WEST SUSSEX COUNTY COUNCIL CONSULTATION

TO:	Arun District Council FAO: Simon Davis
FROM:	WSCC - Highways Authority: Tim Townsend
DATE:	18 March 2019
LOCATION:	Land off Burndell Road Yapton.
SUBJECT:	Y/98/18/RES Approval of reserved matters (access, appearance, landscaping, layout and scale) following outline permission Y/19/16/OUT for 108 residential dwellings, with associated parking, road/footway/cycleway provision, open space, landscaping, surface water attenuation and ancillary works.
DATE OF SITE VISIT:	N/A (for purposes of this specific application)
RECOMMENDATION:	Advice
S106 CONTRIBUTION TOTAL:	£ N/A for purposes of this specific planing application

scheme: Land off Burndell Road  
Yapton  
client: Bovis Homes  
drawing: Hard Landscape Proposals  
date: Nov. 2018  
scale: 1:200@A1  
drawing no: BOV22172 12A sheet 1  
drawn: AE checked: DKM

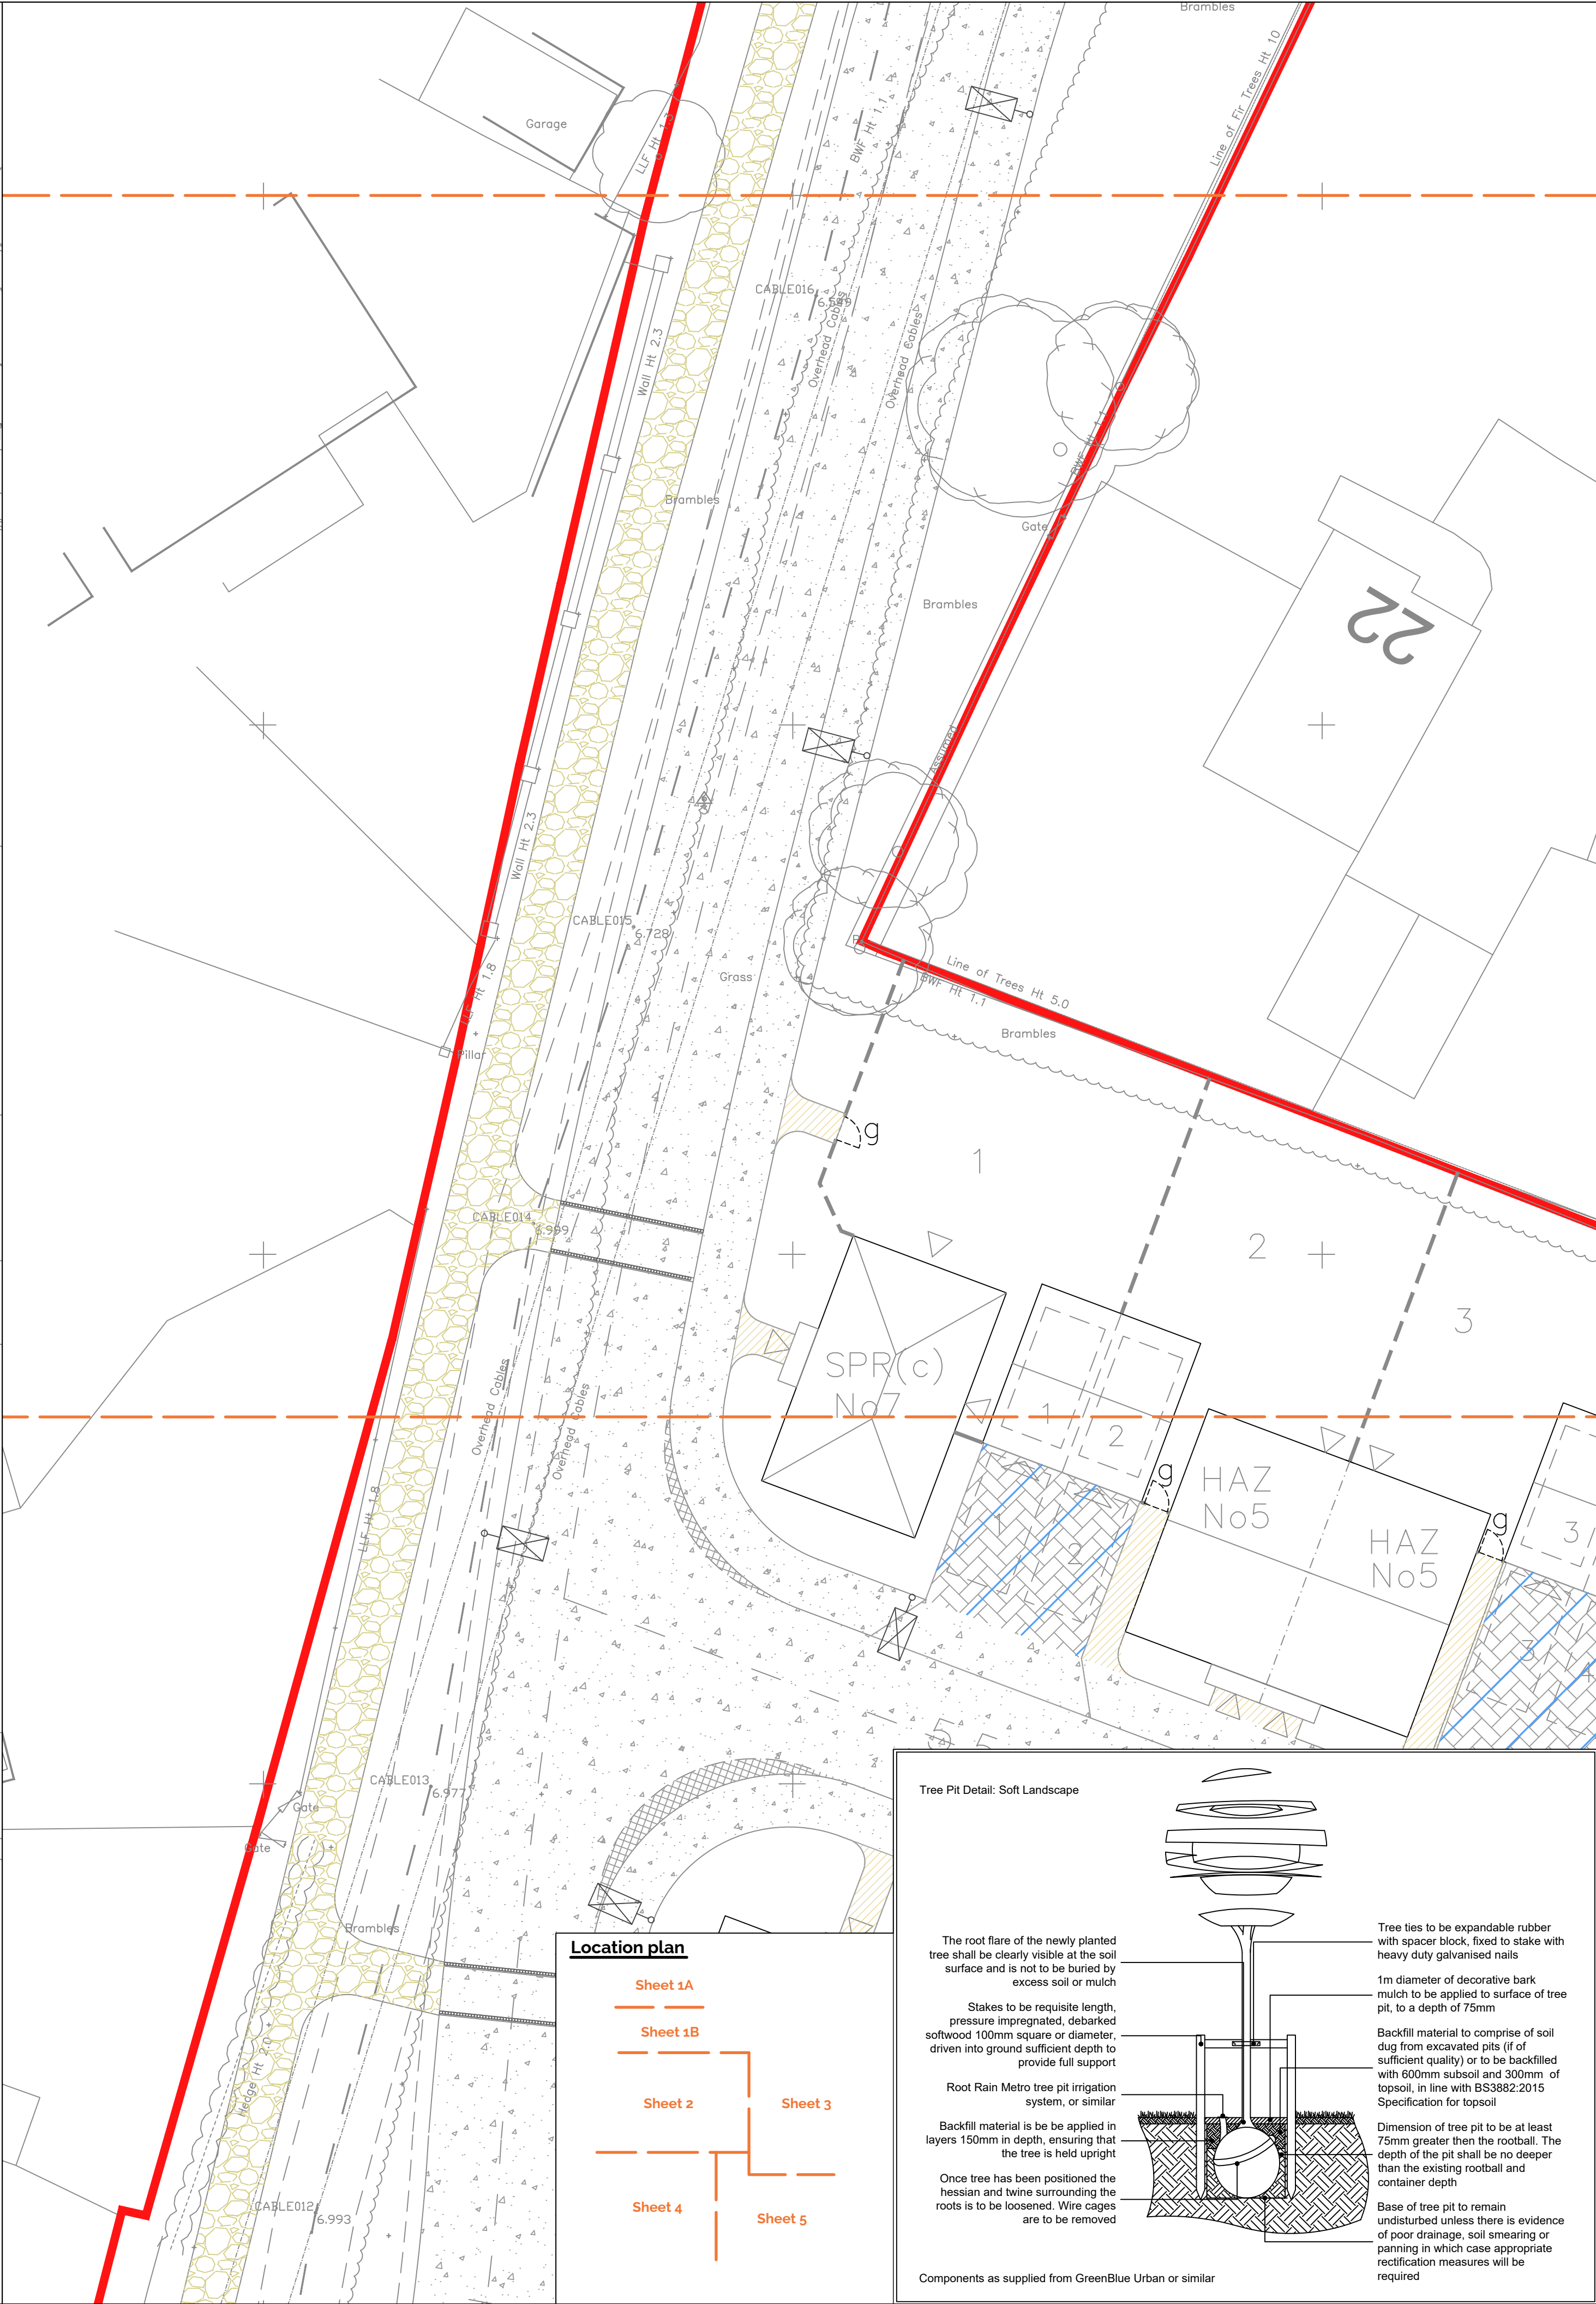
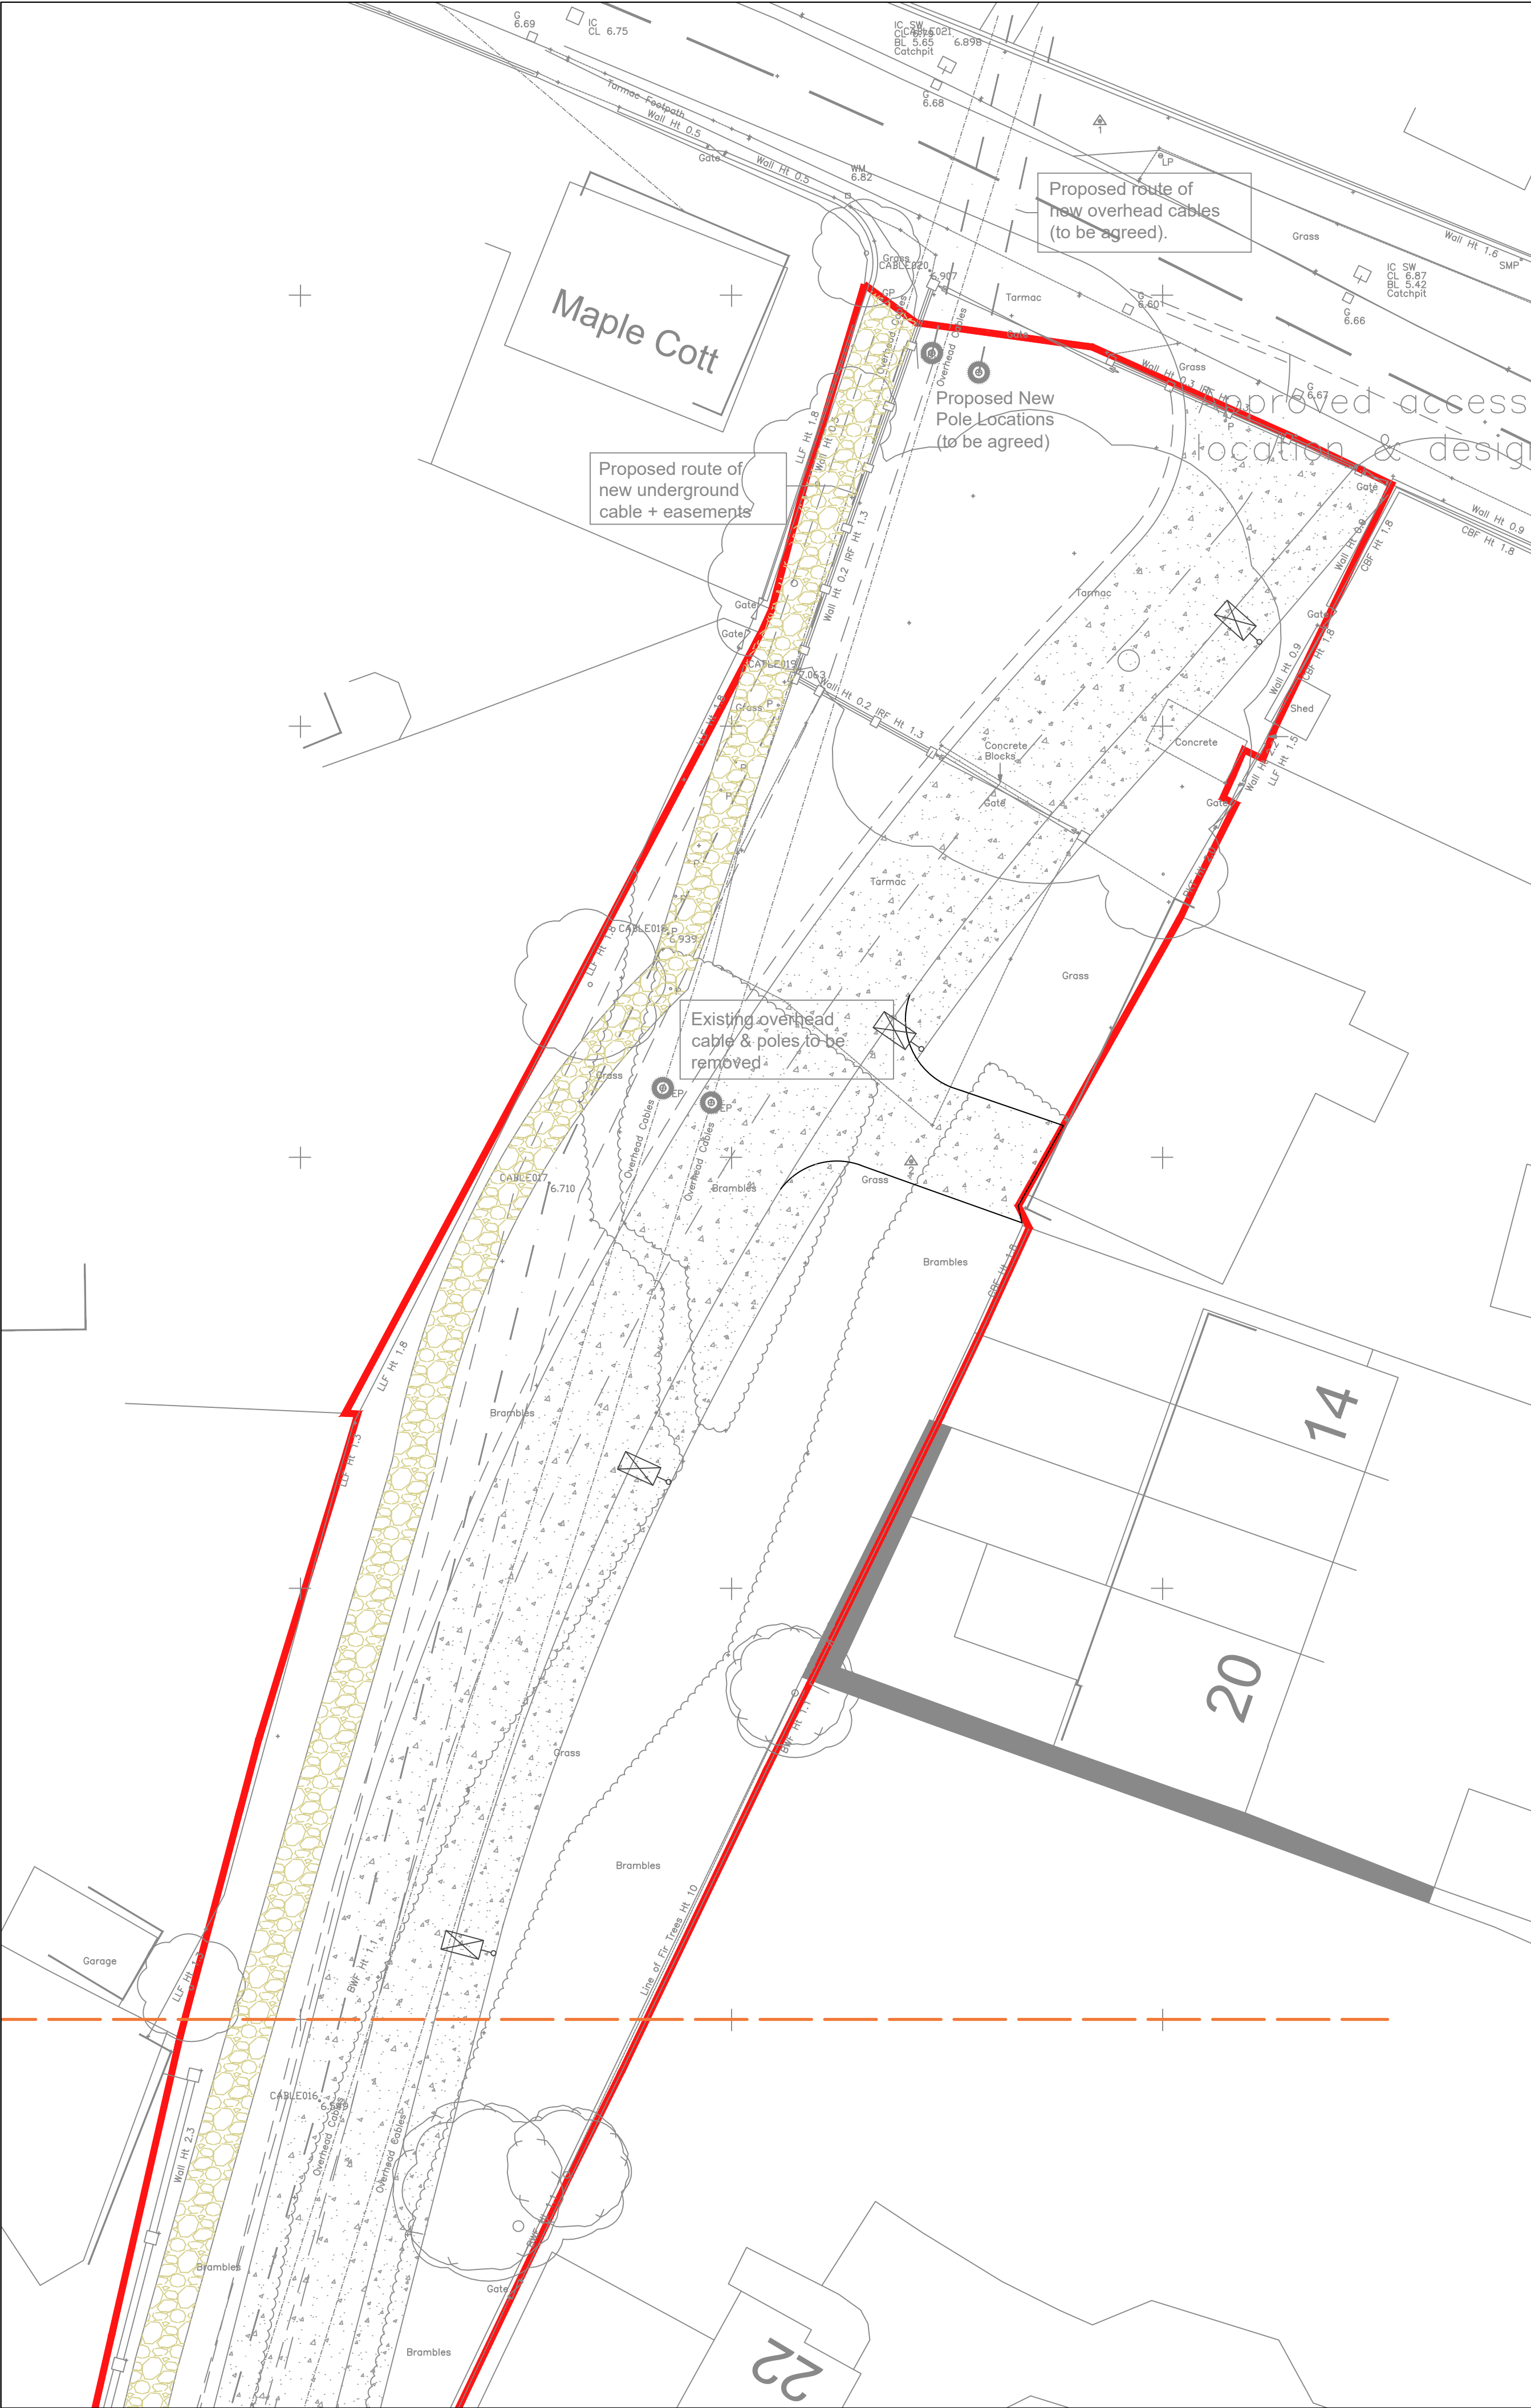
- 1. Condition 7 (landscaping)** – The applicant should ensure that any landscaping in areas required for visibility purposes (including that required for pedestrians) alongside accesses and road junctions be limited to grass or hard landscaping with a maximum height (when mature) of no greater than 0.6m. For any hard landscaping/materials used on the existing Public Right of Way (PRoW) within the site, comments will be forthcoming directly from the PRoW team to the case officer.
